**KIRKLEES METROPOLITAN COUNCIL
INVESTMENT & REGENERATION SERVICE**

DELEGATED DECISION TO DETERMINE PLANNING APPLICATIONS

Reference No:	2025/62/90815/E
Site Address:	25, Hall Park Avenue, Liversedge, WF15 7EH
Description:	Alterations to integral garage to extend living accommodation
Recommending Officer:	Edward Cheseldine

HOUSEHOLDER DELEGATED REPORT

DRAWING NAME:
Proposed Elevations

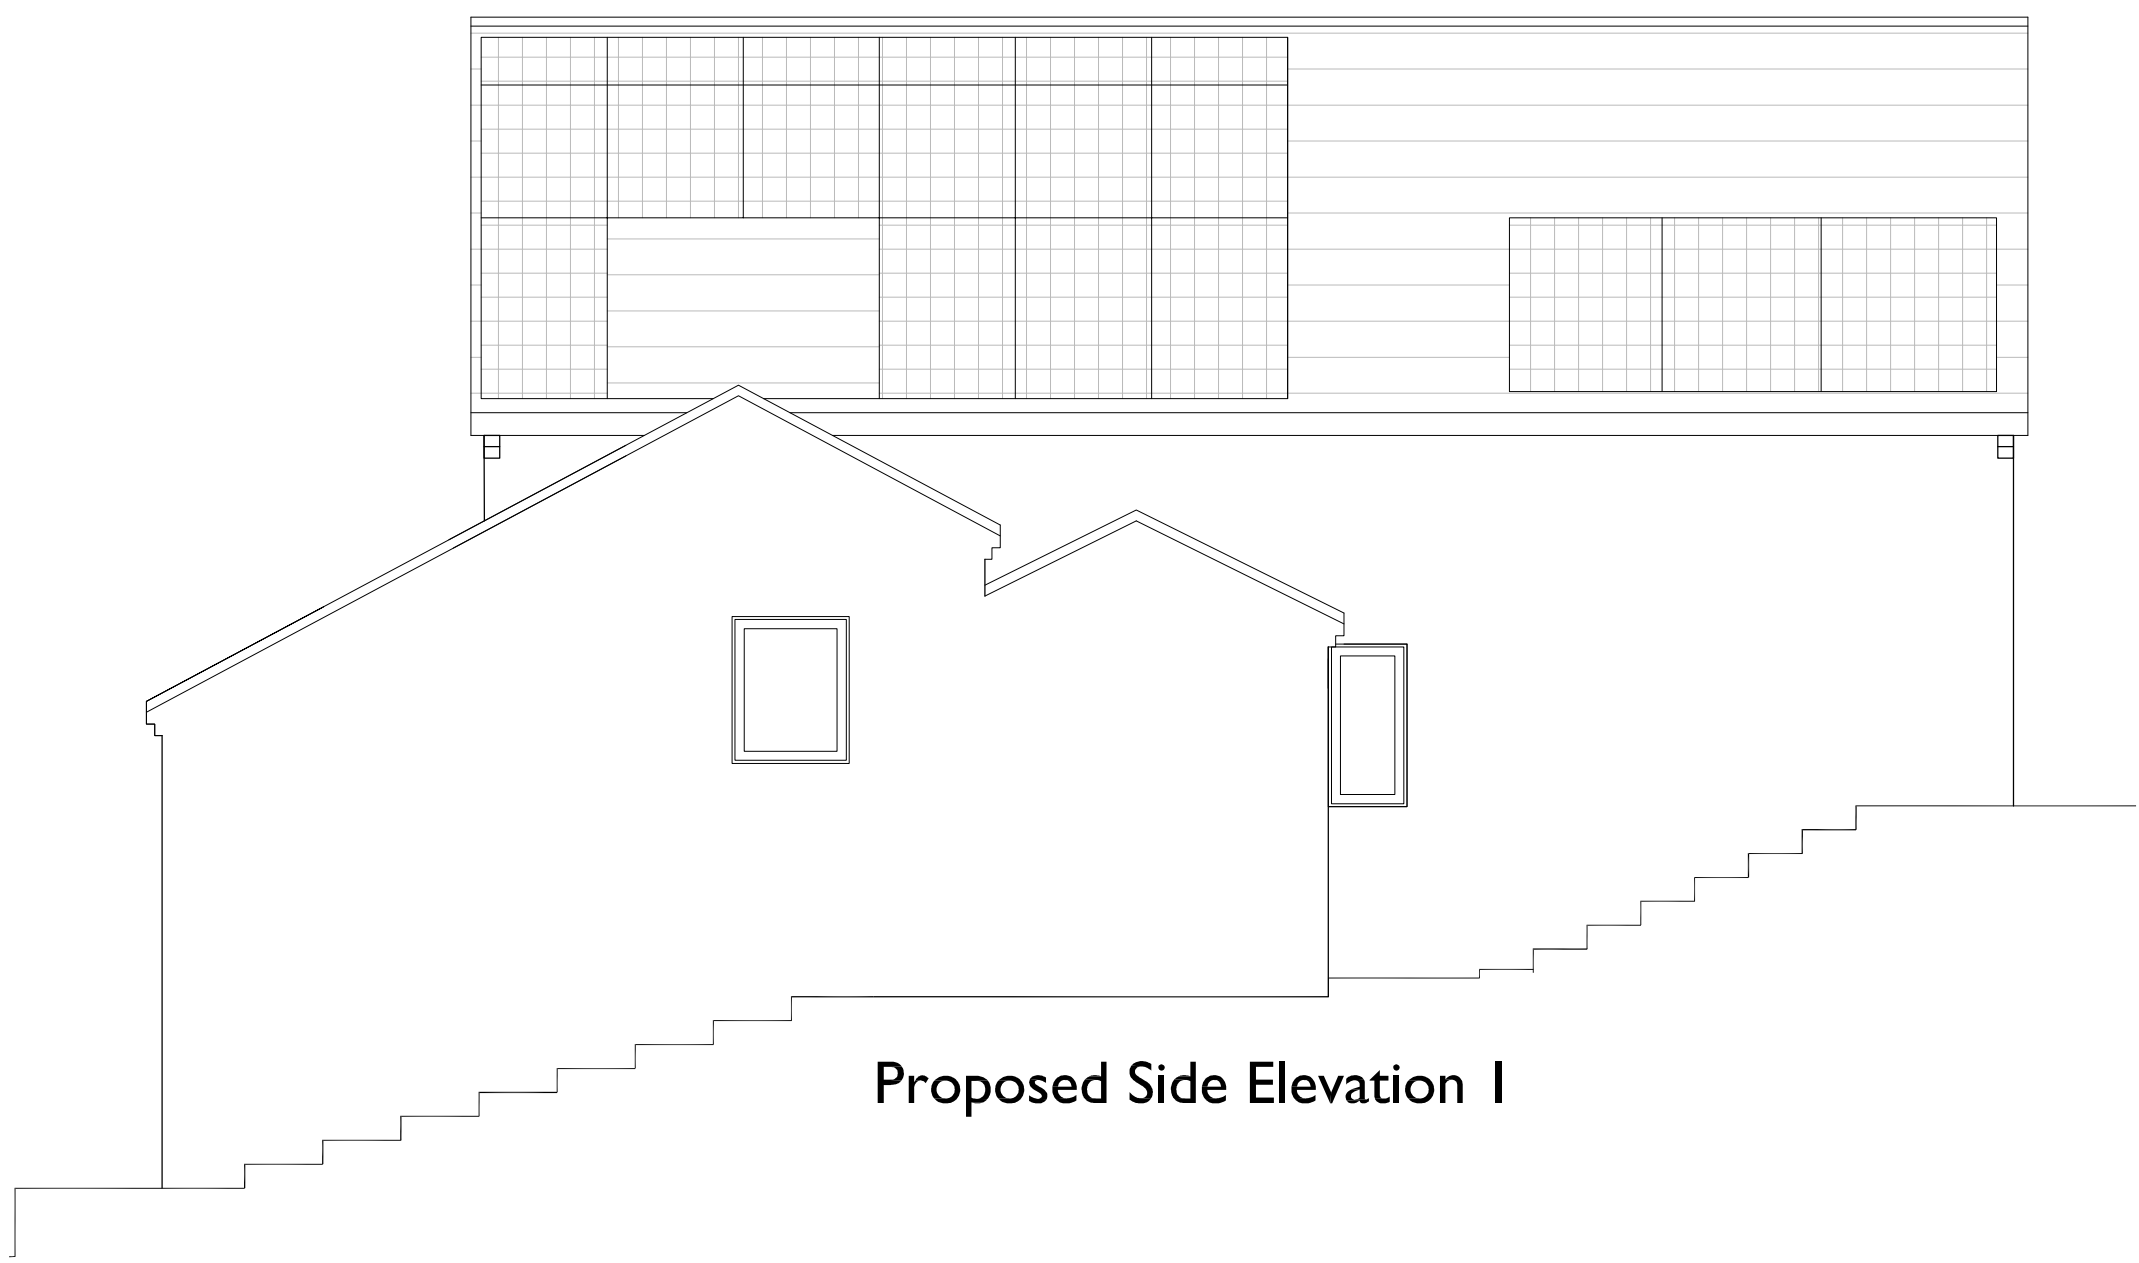
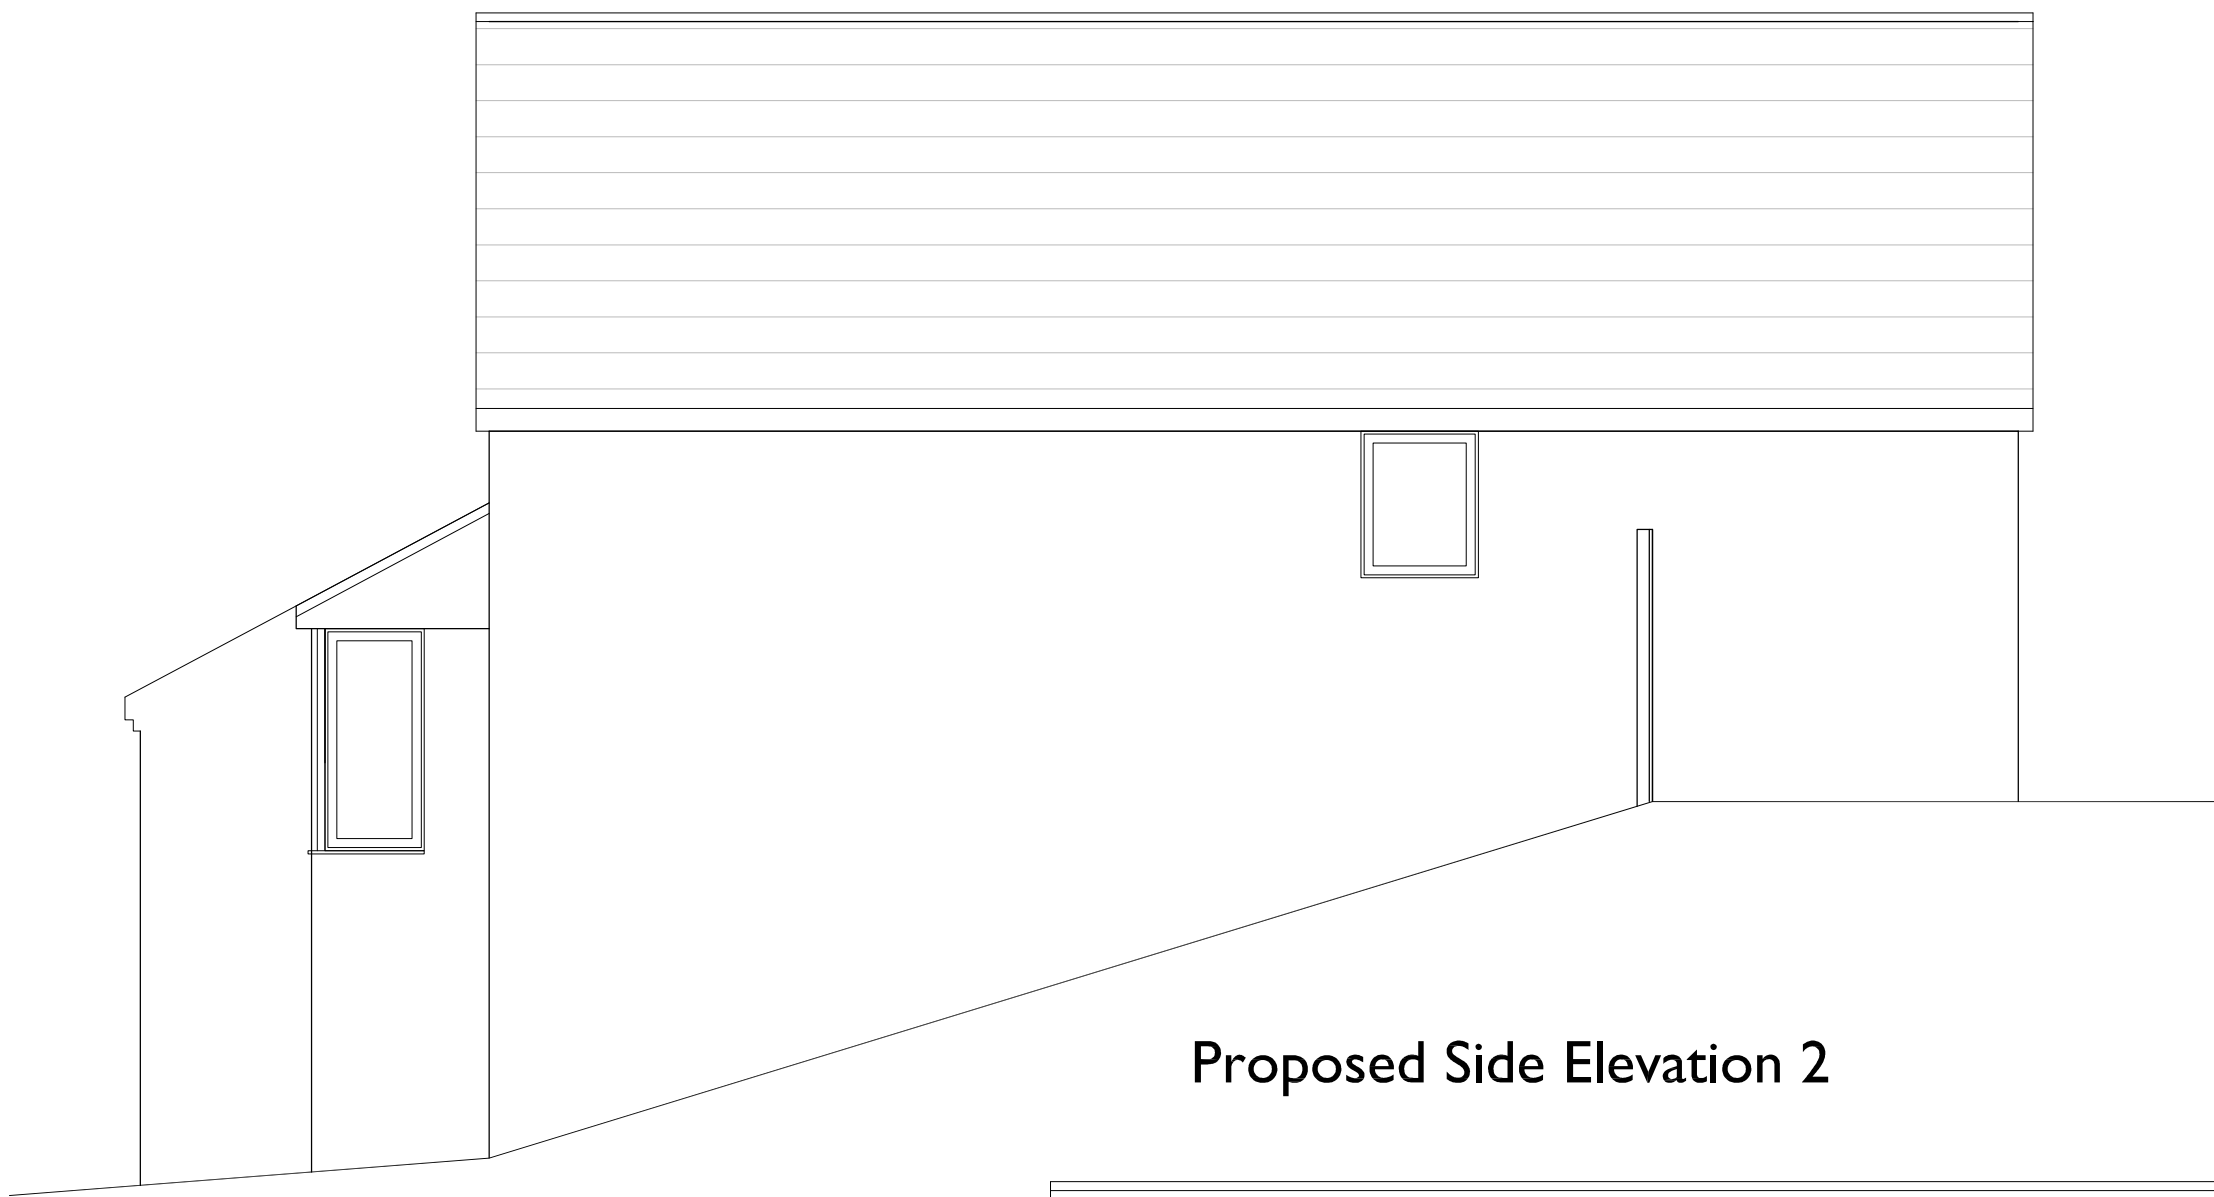
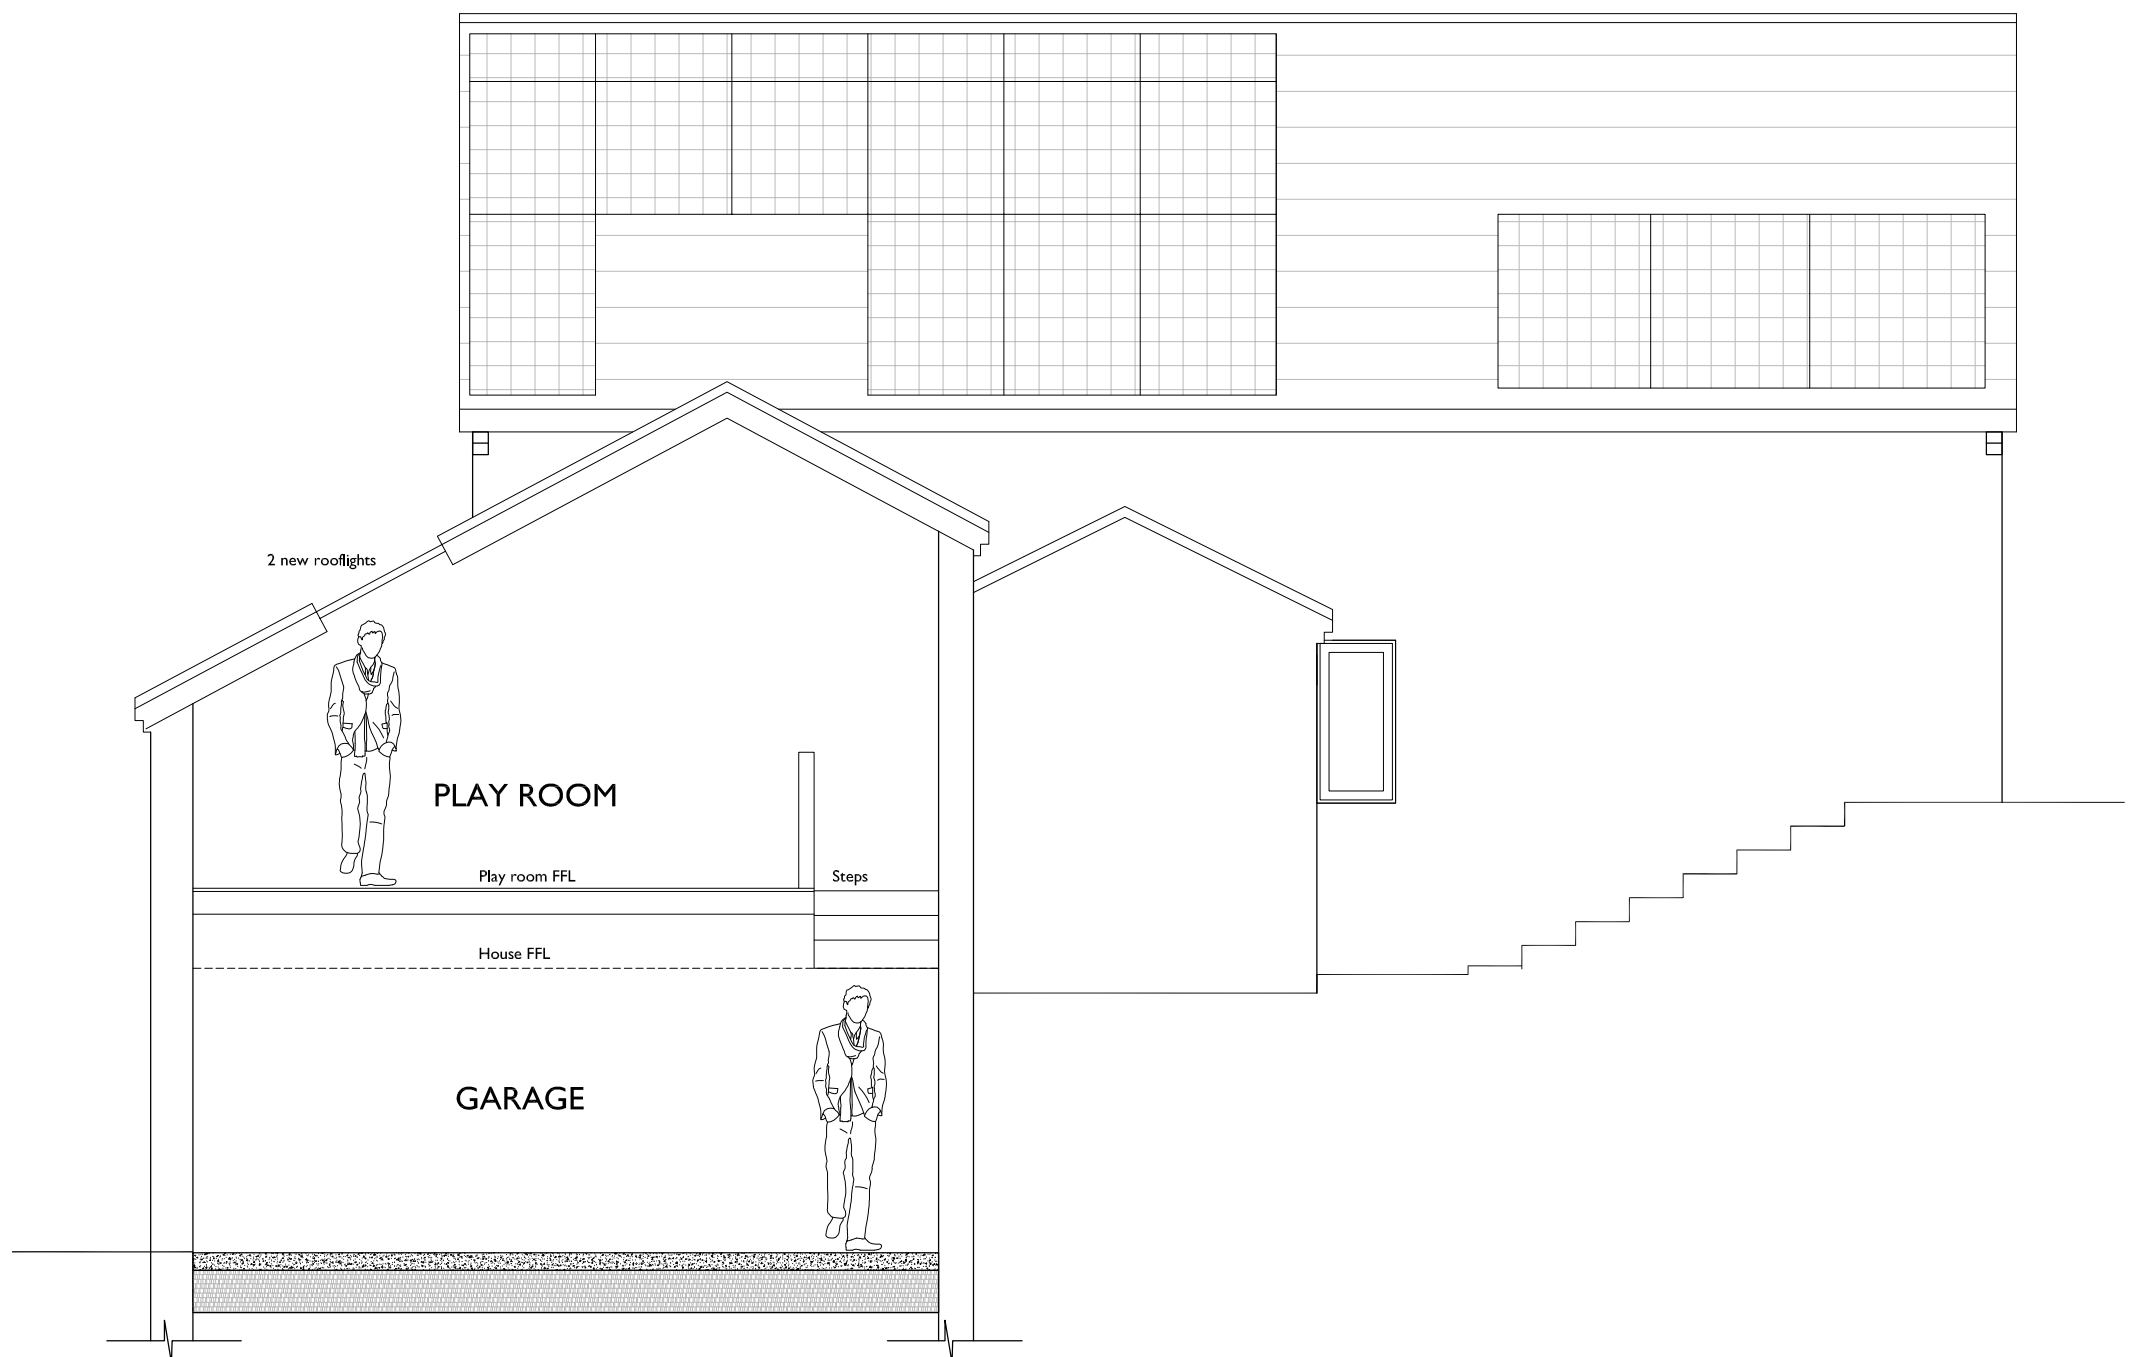
Works are for an infill area of space above the existing garage area, which currently sits at a ground-floor level. The infill area will increase the height of the roof space, which will be assessed as a first-floor side extension.

<u>Yes - COMPLY</u>	<u>No - JUSTIFY</u>
Ideally be visually smaller in relation to the original house	Yes - the infill area is modest, it sits below the eaves of the dwelling and retains the pitched roof feature.	
Be set back at least 500mm from the front of the original house to provide a vertical break from the roof plane and for the lowering of the ridgeline from the original house		The infill area sits on top of the existing garage. It is not set back, however the architectural features dwelling is retained, such as the garage and the front facing pitched roof, therefore there is a vertical break in the building.
Have a roof design that follows the form of the existing roof	Yes – the pitched roof is retained.	
Retain a gap of at least 1 metre to boundary walls to avoid a terracing effect and to	Yes – a 1.0m to the side of the property will be retained.

Relevant key design principle (KDP) of the SPD, Policy in the Kirklees Local Plan and the NPPF	Further comments	✓ / X / N/A
Impact on the Local character and street scene	<ul style="list-style-type: none"> • KDP1 of the SPD • Policy LP24 Design (a) and (c) of the KLP • Chapter 12 NPPF 	The extension will increase the height of the garage section. The dwelling is set back from the road. It is considered a minor alteration, therefore preserving the character of the area.	
Impact on original house	<ul style="list-style-type: none"> • KDP2 of the SPD • Policy LP24 Design (c) and (d) of the KLP • Chapter 12 of the NPPF 	The extension will appear subservient and retain the frontal features of the building.	
Height, scale and massing	<ul style="list-style-type: none"> • KDP 1 and 2 of the SPD • Policy LP24 Design (a), (c) and (d) of the KLP 	The height and mass of the building will be slightly increased above the garage, however this section of the building will appear subservient to the main dwellinghouse.

<ul style="list-style-type: none"> Chapter 12 of the NPPF 		
Facing materials and detailing	<ul style="list-style-type: none"> KDP 9 of the SPD Policy LP24 Design (d) (iii) of the KLP Chapter 12 of the NPPF 	Materials will match the existing dwellinghouse.	
Roof style	<ul style="list-style-type: none"> KDP 1 and 2 of the SPD Policy LP24 Design (a), (c) and (d) of the KLP Chapter 12 of the NPPF 	A pitched roof will be increased in height, respecting the appearance of the current roof styles.	
Window proportions	<ul style="list-style-type: none"> KDP 1 and 2 of the SPD Policy LP24 Design (a), (c) and (d) of the KLP Chapter 12 of the NPPF 	Two skylights and a side window will be installed. They are modest in size and respect the size of the existing windows.

Relevant key design principle (KDP) of the SPD, Policy in the Kirklees Local Plan and the NPPF	Further comments	✓ / X / N/A
Impact on privacy of neighbours (to sides, rear and front)	<ul style="list-style-type: none"> KDP 3 & 4 of the SPD Policy LP24 Design (d) (iv) of the KLP Chapter 12 of the NPPF 	A side window will be installed that lights a playroom. It will host a view of a side wall of the neighbouring property which sits along the boundary. Due to its

outlook, there will be no impact to privacy.	
Impact on light and outlook of neighbours (to sides, rear and front)	<ul style="list-style-type: none"> • KDP 4, 5, 6 of the SPD • Policy LP24 Design (b) • Chapter 12 of the NPPF 	The roof of the side section of the building will be increased. The roof will fall under the height of the main ridgeline. The increase in height is not considered to lead to a loss of light or outlook.
